**Sent:** 23 December 2009 18:47  
**To:** Planning  
**Subject:** Comments Added: LAND AT HORNBEAM LANE (SPIKE ISLAND), BROOKMANS PARK

Application ID: S6/2009/2574/FP Mrs L Hughes Application Owner: Welwyn & Hatfield Borough Council (Development Control Officer)

Description: ERECTION OF NEW DWELLING, THREE BAY GARAGE BLOCK, GARDEN STORE TOGETHER WITH RETENTION AND ALTERATION OF THE EXISTING STABLES, LANDSCAPING AND ALL OTHER ANCILLARY WORKS. FOLLOWING DEMOLITION OF PART

Comment: Essendon Public Bridleway 018 and Public Footpaths 19 and 20 Application No. S6/2009/2574/FP

Site Layout:

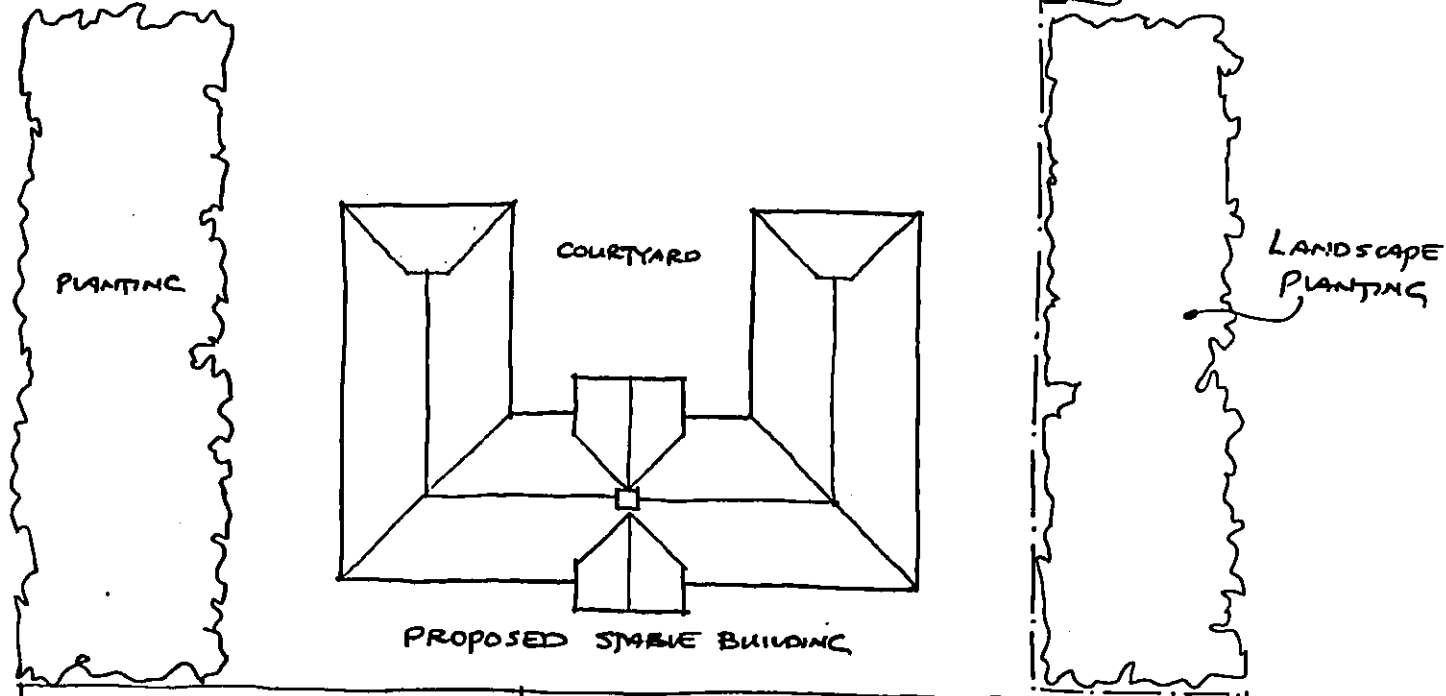
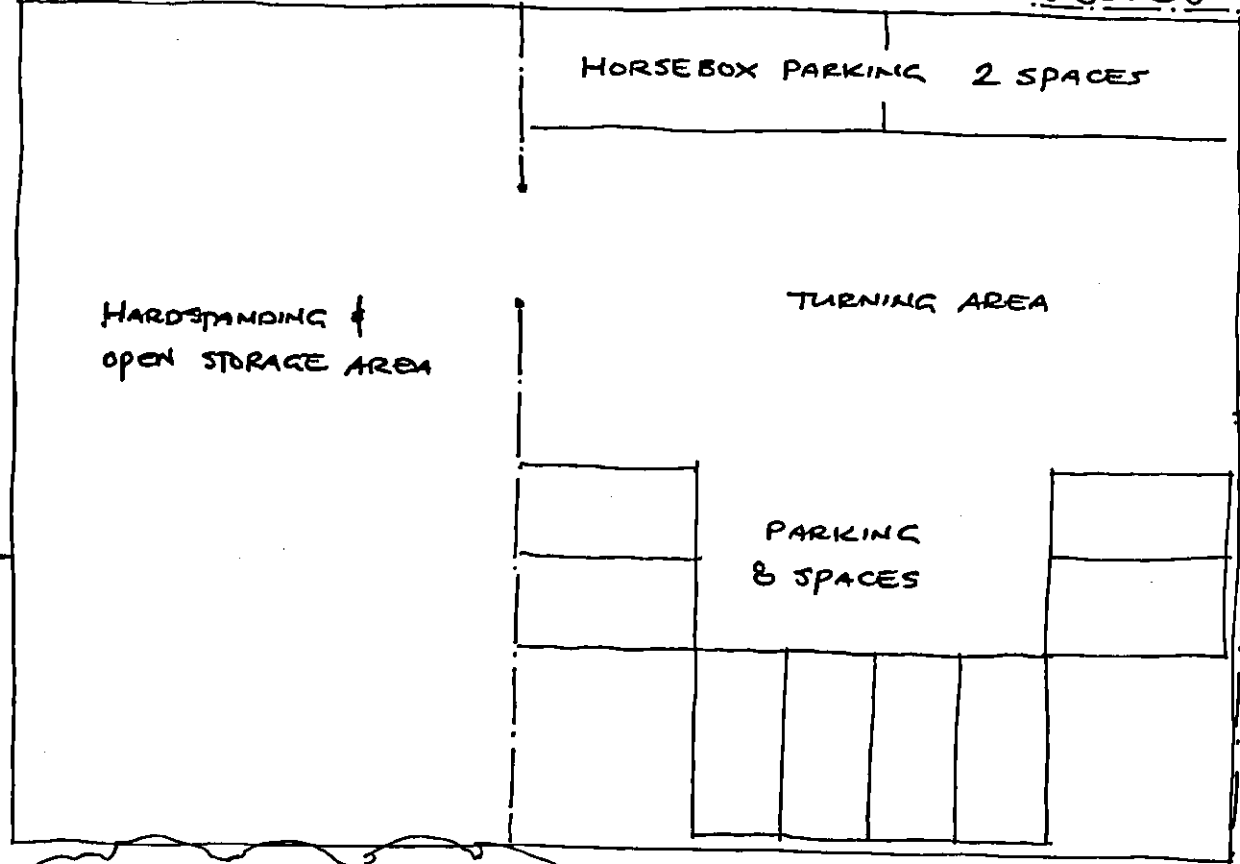
Regarding the public footpaths across or adjoining the site, any fencing off of these routes would need to give a generous width (3 to 4 metres), as the public has been able to walk unrestrained along them. However, it should be noted that if the public have walked a wider width than this, they may apply to us (with evidence) to have a wider width recorded.

Point 7.18 of the Landscape and visual Appraisal states, that stiles will be erected on these public footpaths. Any structure to be erected on a public right of way must

be authorised by us. Legally the County Council as Highway Authority only has two powers to erect structures on footpaths, bridleways and restricted byways. One is section 66 of the Highways Act 1980 for safety and the other is section 147 for controlling animals for agricultural purposes. The default position is not to restrict the public highway at all; therefore any access restriction needs to be justifiable.

In order to use section 147, the land has to be in use for agriculture and the structure has to be needed to control the ingress or egress of animals. We also no longer consider stiles appropriate under the Disability Discrimination Act 1995 and any structure that is approved by us must be made and installed to the current British Standard BS7709.
